03 August 2021

**Kamay Ferry Wharf Project (SSI 10049) – Exhibition of Environmental Impact Statement
Sutherland Shire Council Draft Submission**

Figure 5-5: Kurnell wharf design features

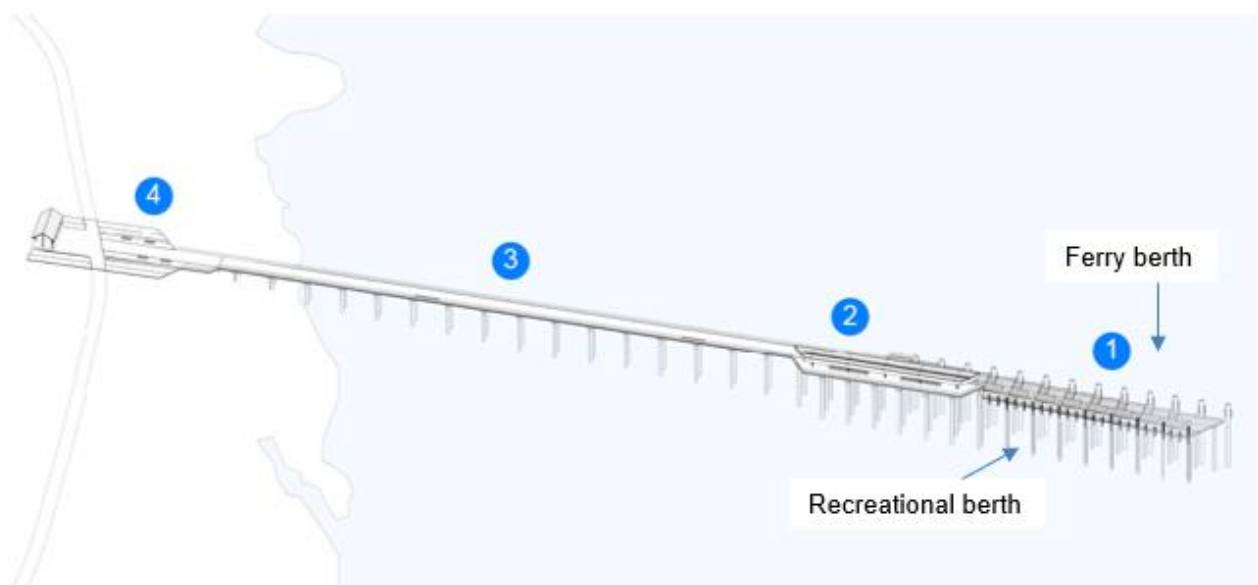
The project is schematic and accordingly it is difficult to comment on the detailed design. The concept design as illustrated in the artist's impression comprises entirely rectilinear forms and large concrete surfaces. A curved connection from the ferry berth to the foreshore would better relate to the natural features, as would the use of more natural materials such as weathered timber and stone. Other ideas are to consider sail shapes in devising weather protection of the waiting areas, and the provision of facilities for recreational fishing in the form of 'side pods' placed randomly along the long walkway so this is not just a ferry terminal but also a 'gathering' place.
